# FINAL DRAINAGE PLAN

## CREEKSIDE AT LORSON RANCH FILING NO. 1

**SF-19-00X**

**Engineering Review**

CAUTION!!!
 EXISTING UTILITIES TO BE PROTECTED FROM DISTURBANCE DURING EARTHWORK AND SOIL/RIPRAP INSTALLATION.

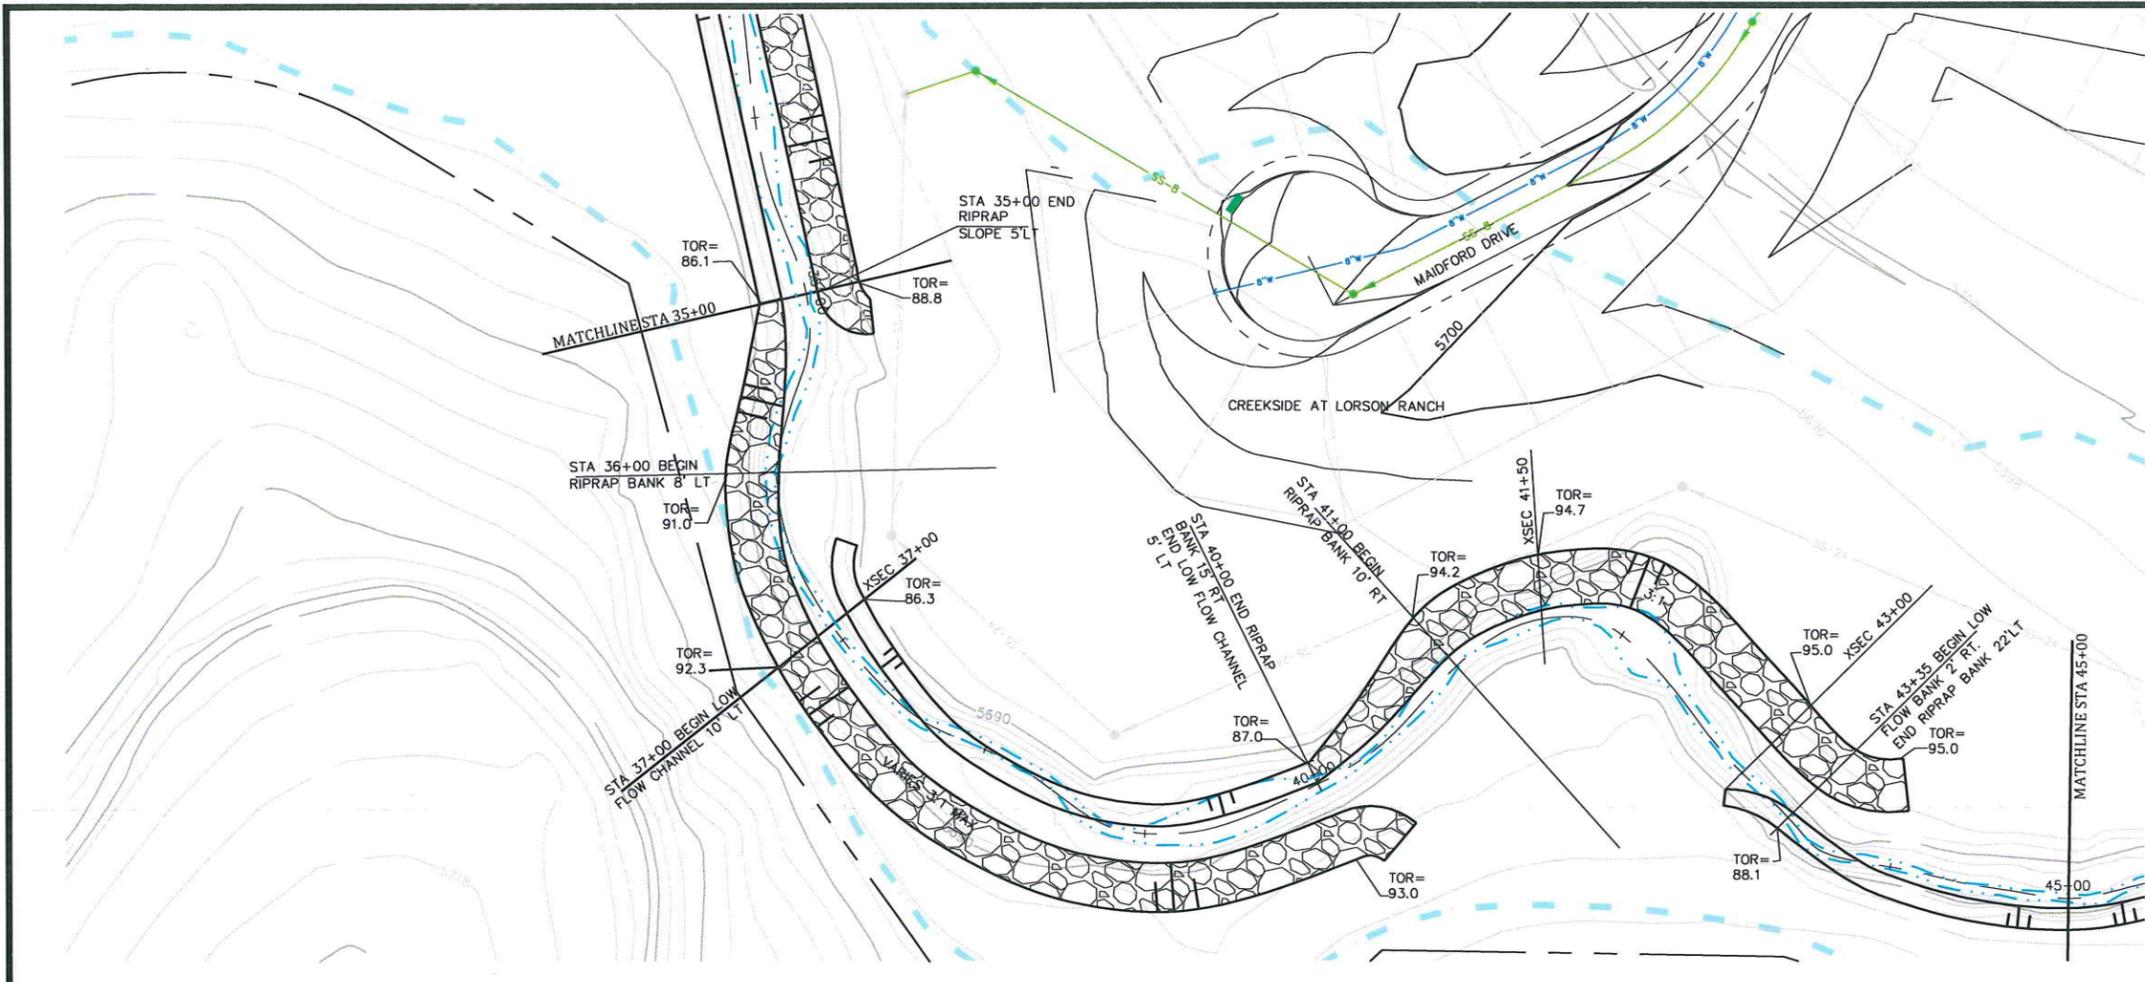
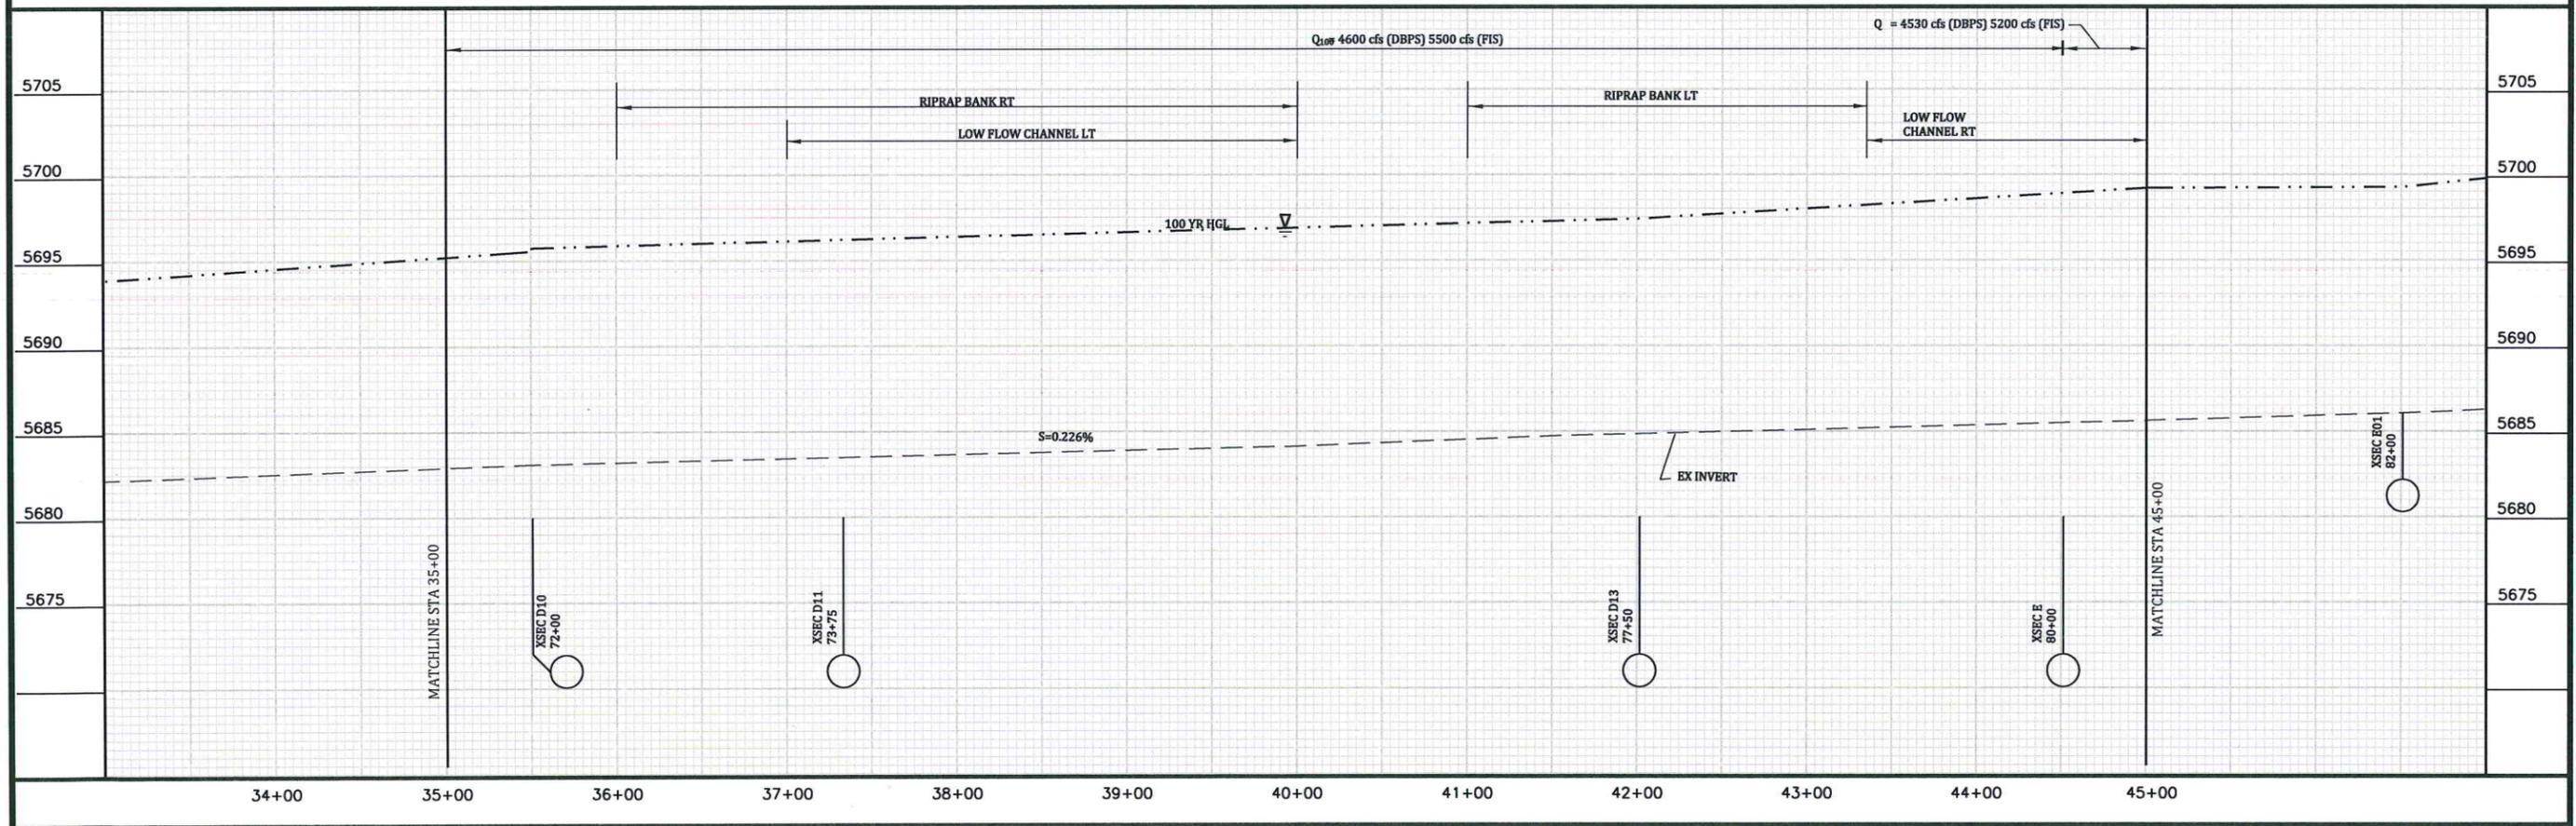
## Address what's being done. Is there a separate channel design report?
